Consultation Response from: KC Environmental Health (Pollution & Noise Control)
2023/91408 - Land adj, 21, Thomas Street, Lindley, Huddersfield, HD3 3JJ
Erection of care home (Class C2) with sub-station, associated car parking, access, servicing, landscaping and other associated works
Date Responded:
4th July 2023
Responding Officer:
NH
Responding Ref:
WK/202318294

Drawing Title  
Proposed Site Plan

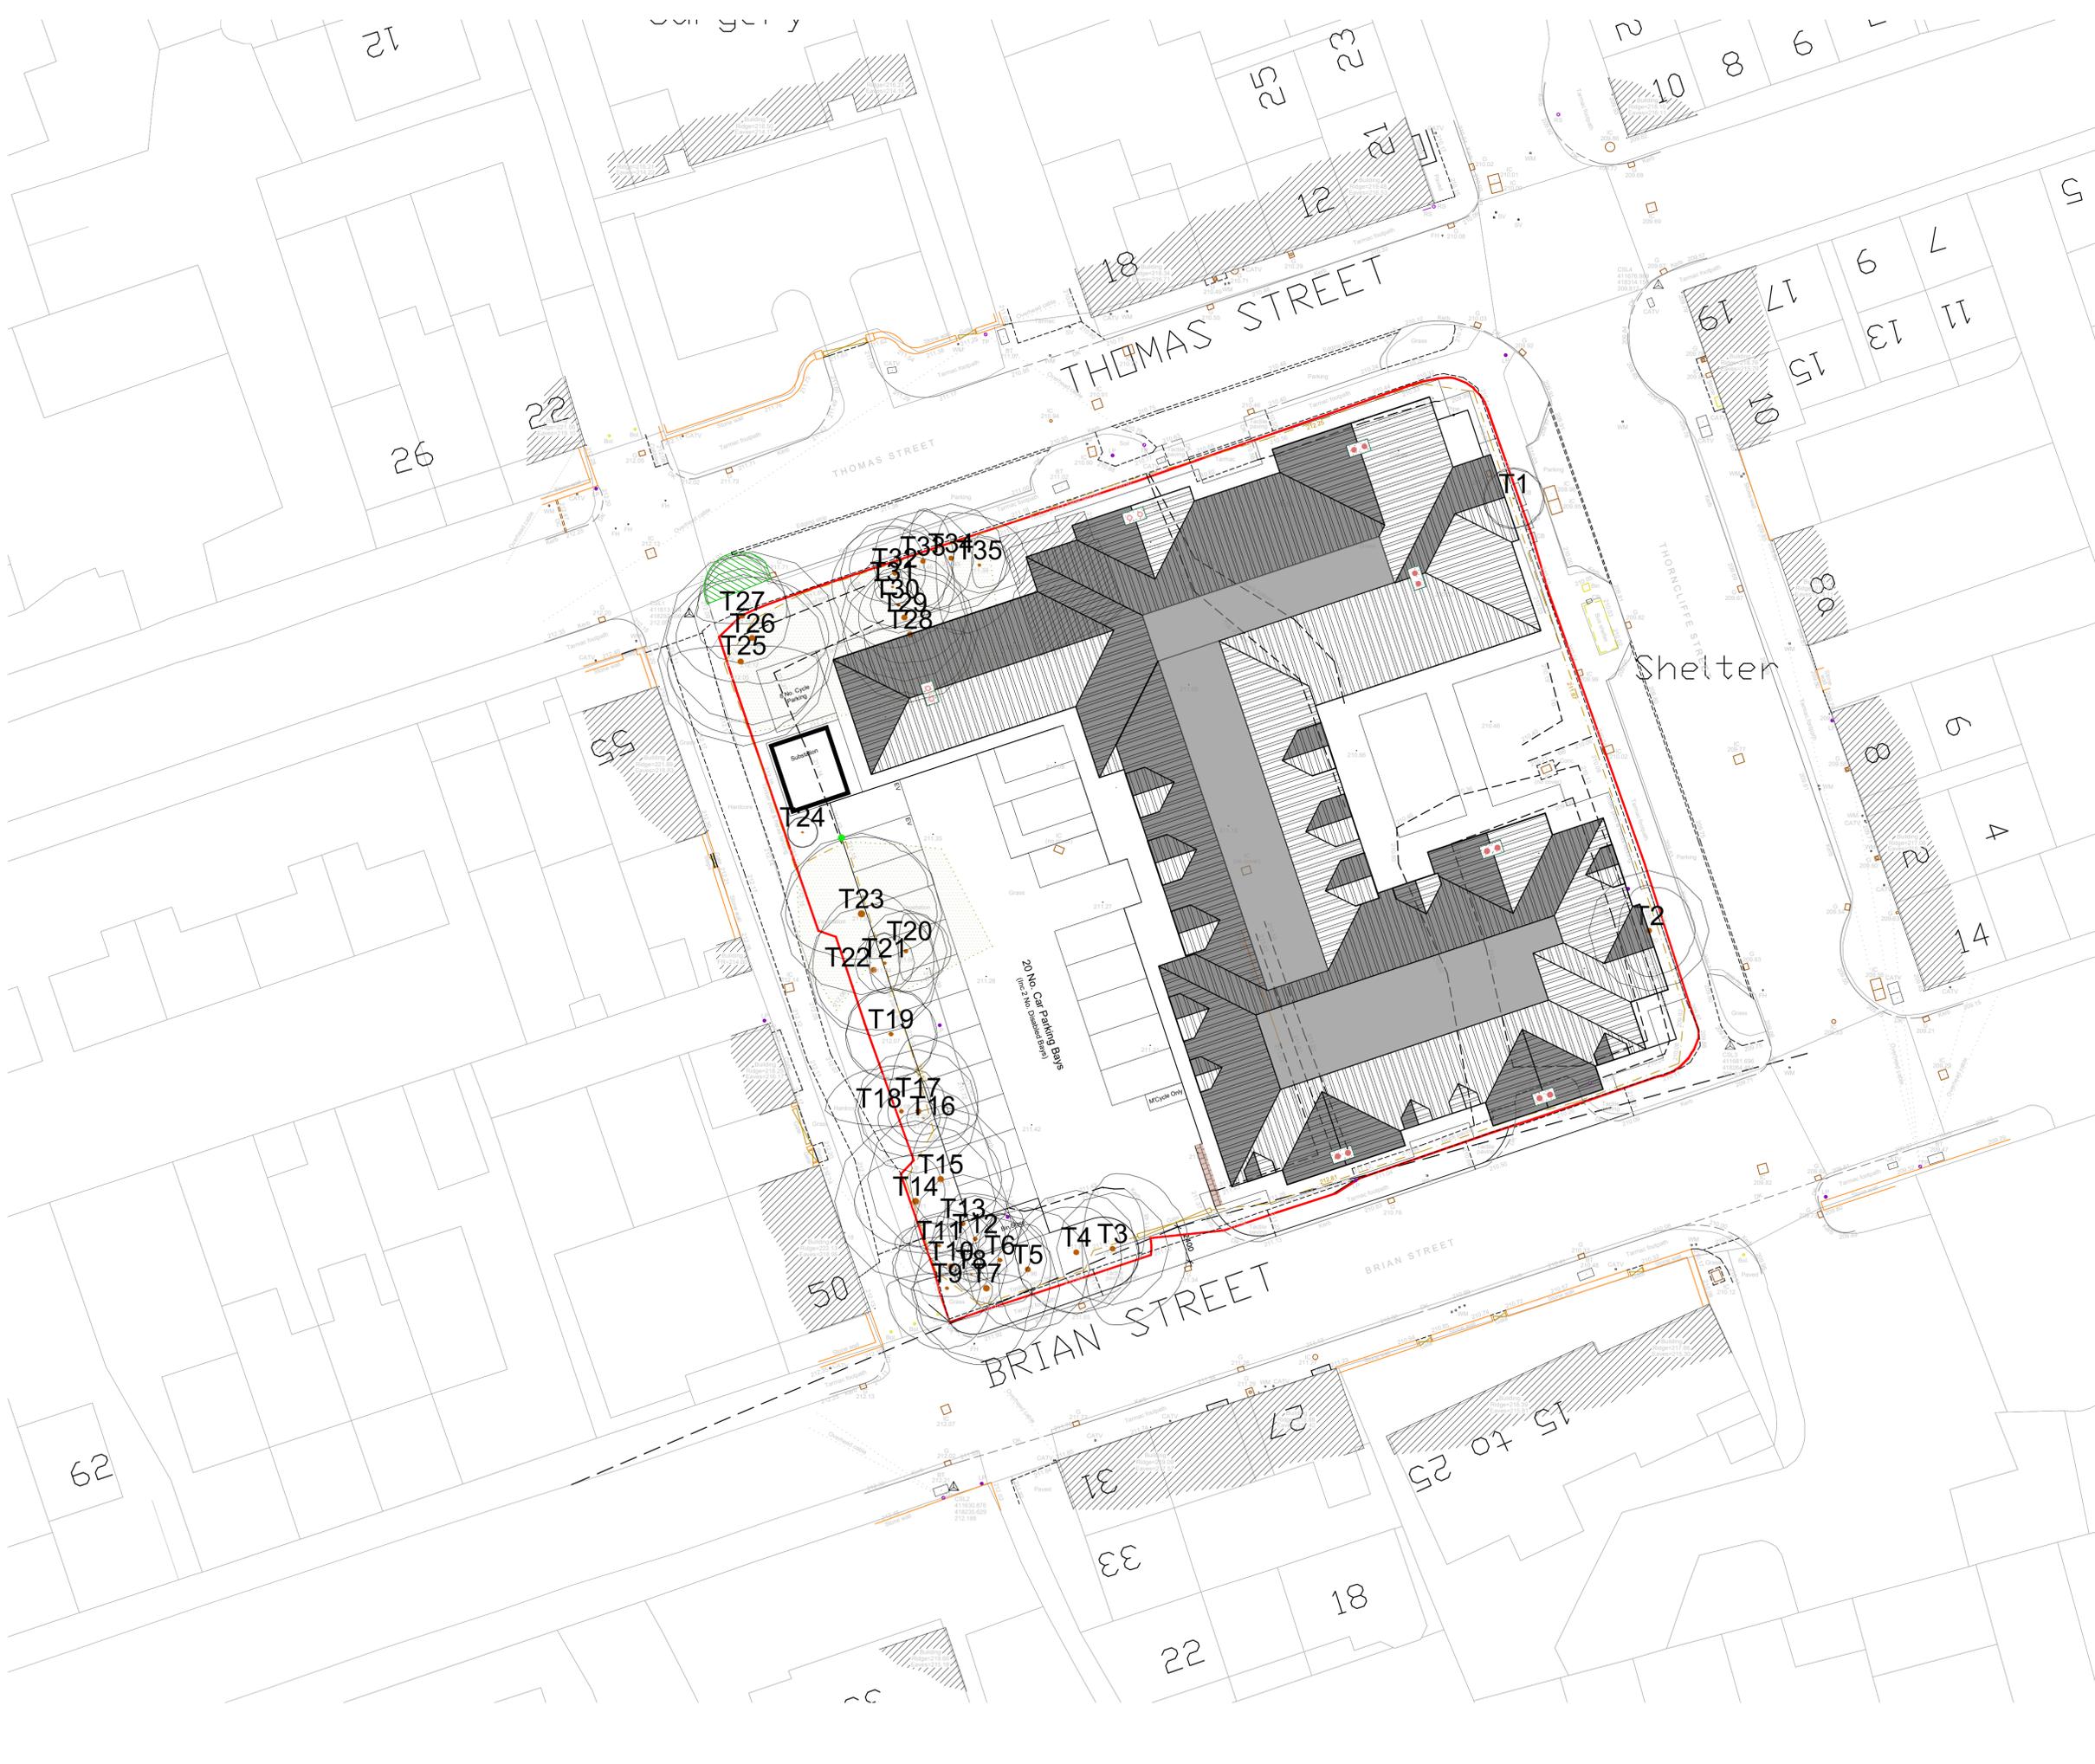
On-site parking is proposed, and we can see from the Proposed Site Roof Plan by ADG Architects, dated 2nd May 2023 (ref: H.21.81). In an application of this nature, it is expected that facilities for charging electric vehicles and other ultra-low emission vehicles are provided in accordance with the National Planning Policy Framework and *Air Quality & Emissions Technical Planning Guidance* from the West Yorkshire Low Emissions Strategy Group. As such, a condition requiring charging points is therefore necessary.

Before first occupation, a scheme detailing the dedicated facilities that will be provided at the premise for charging electric vehicles and other ultra-low emission vehicles shall be submitted to and approved in writing by the Local Planning Authority. The scheme shall meet the requirements of the current West Yorkshire Low Emission Strategy (WYLES) document. The approved dedicated facilities for charging electric vehicles shall be installed prior to occupation and retained for use thereafter.
